5 December 2018

Crime Impact Statement

Proposal: 233 dwellings off Whalley Rd, Barrow, Clitheroe

Drawing:
Boundary Treatment Plan

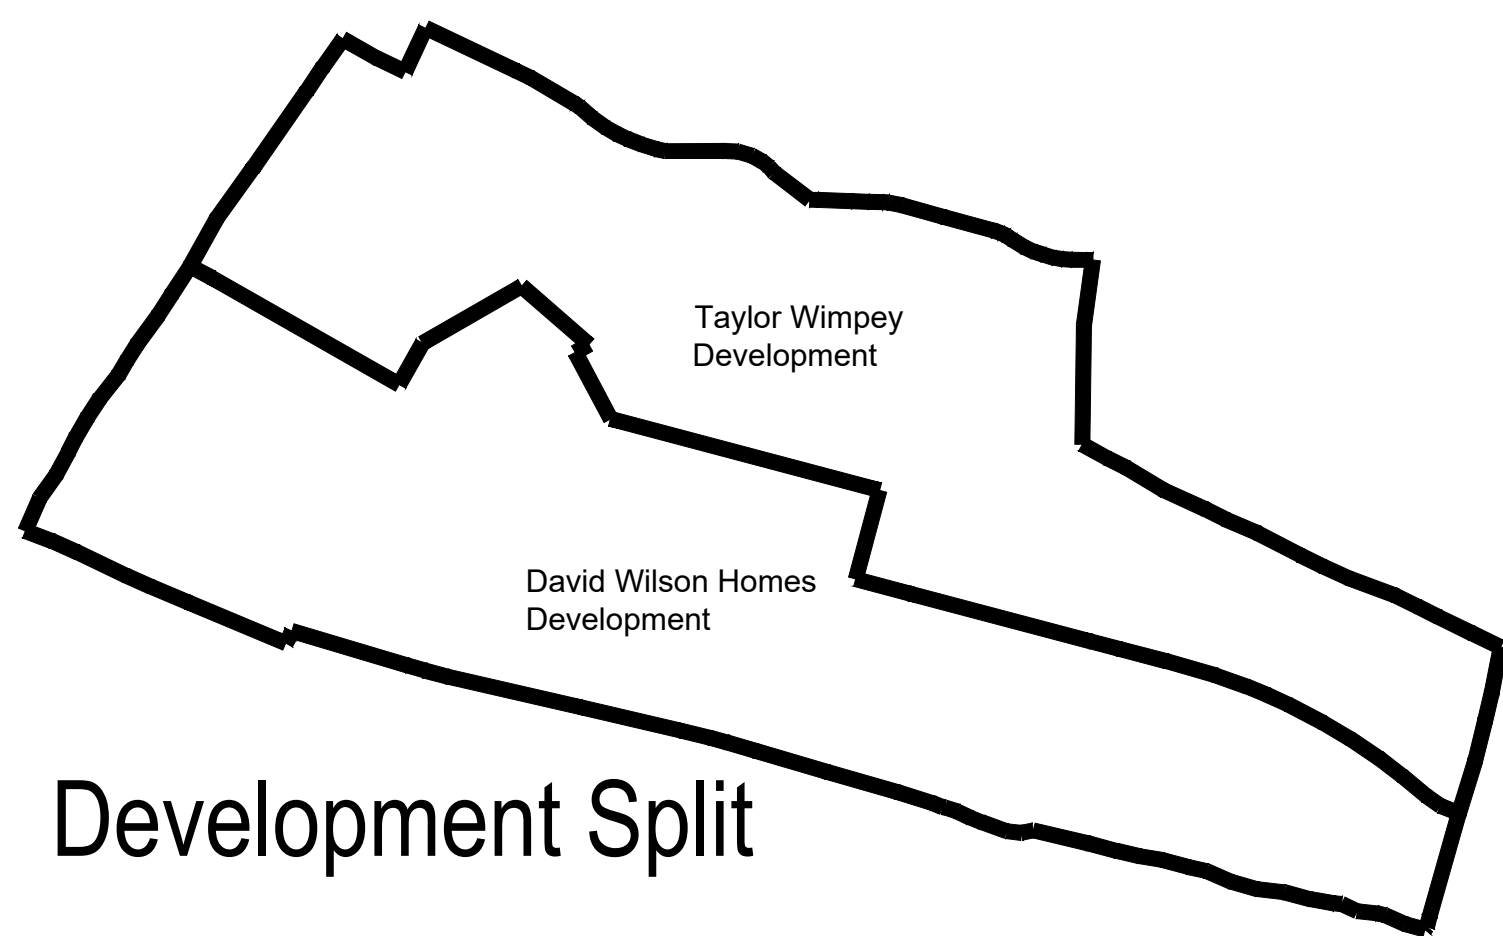
- Boundary treatments should be 1.8m high close boarded timber fence at the side and rear of the plots. A 1.8m high lockable gate should restrict access to the side and rear of the dwellings, this should be fitted as close to the front building line as possible to promote natural surveillance.

Certain plots show gates set back to the rear of the dwellings e.g. plots 166 and 167. These gates should be brought forward to the front line of the dwelling and the gate should be capable of being locked from both sides. This is an important security feature as a high proportion of burglaries occur whereby the offender gains entry into the property via a side or rear ground floor door or window.
